2022/0962

Demolition of existing building and construction of new detached house
Land North of Cooper Lane, Hoylandswaine, Sheffield

ELEVATION 01

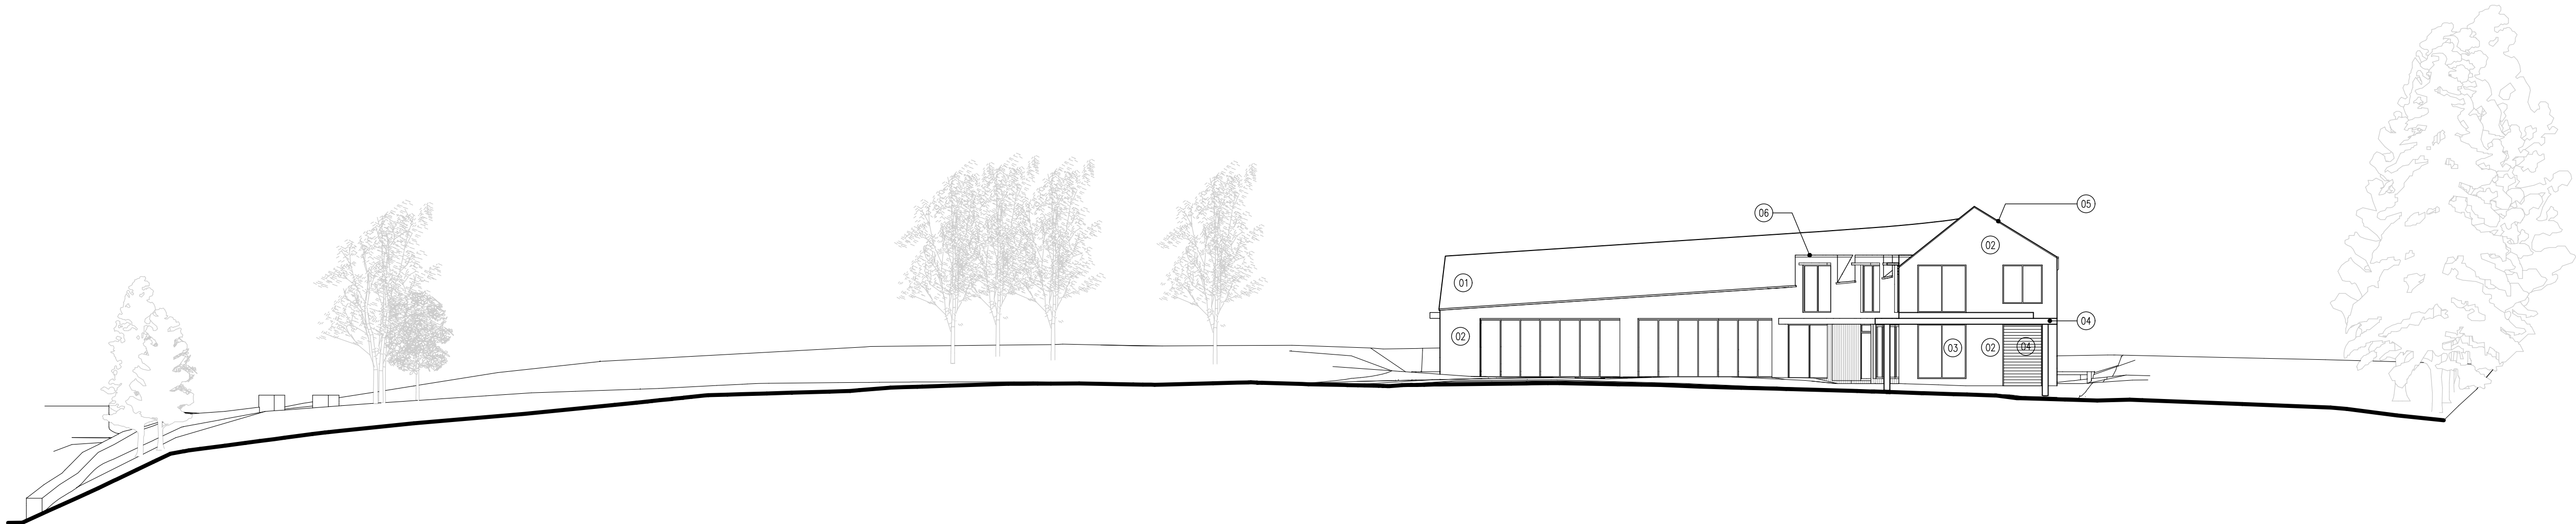
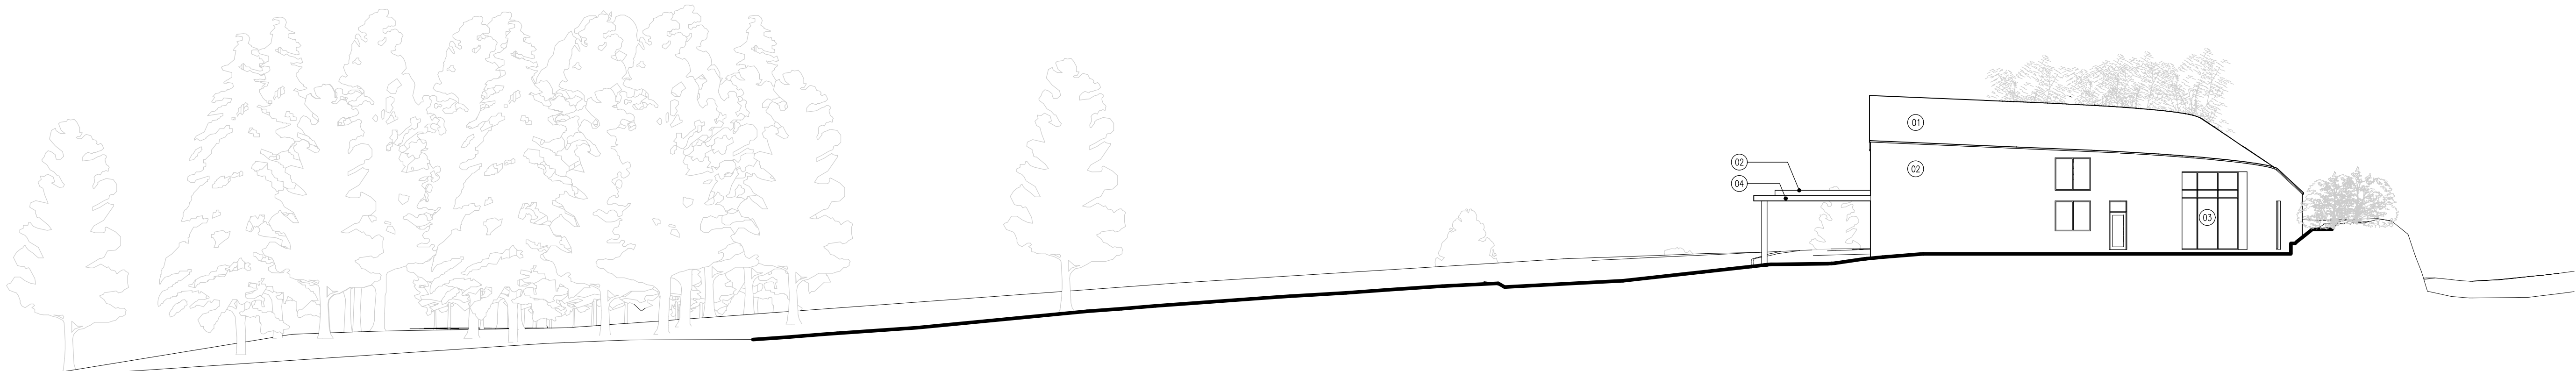
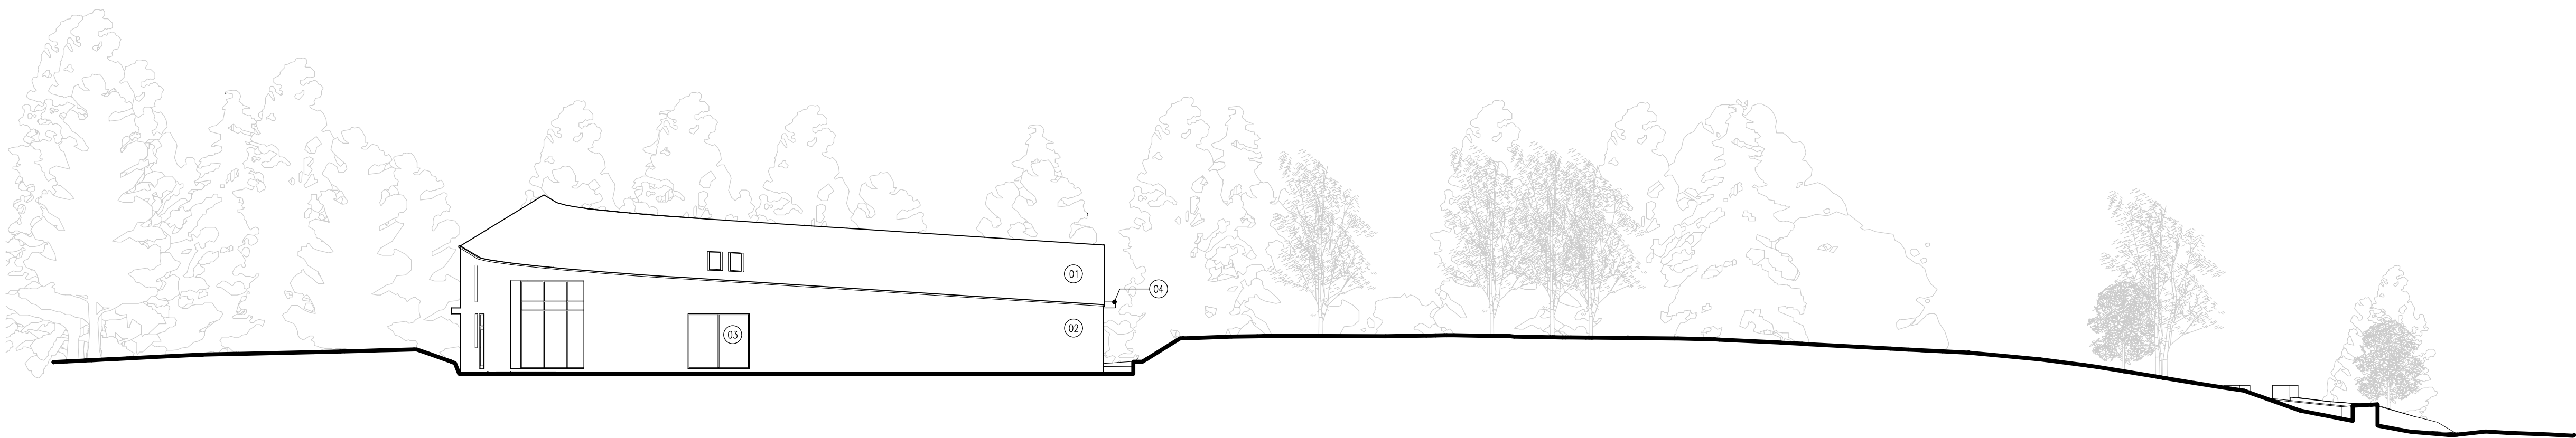
- Impact on the light of the adjacent properties
- The height of the two storey dwelling is not in keeping with the area
- The proposal will have a negative / adverse visual impact on the landscape and be detrimental to the character of the local area and green belt. Other accepted planning applications in the area have all been of a single storey nature which is more in keeping with the area.

aside, the design put forward is a simple, two storey, pitched roof, fully rendered dwelling. The design fails to be sensitive to the defining characteristics of the local area, which include more traditional stone-built farmsteads. Whilst elements of the design could be considered characteristic of some of the properties within Hoylandswaine village, the dwelling is not located within the village, nor is this design considered innovative. No details have been provided in terms of the 'sustainable' materials proposed and the overall design is not considered to be outstanding or innovative in nature contrary to the NPPF.
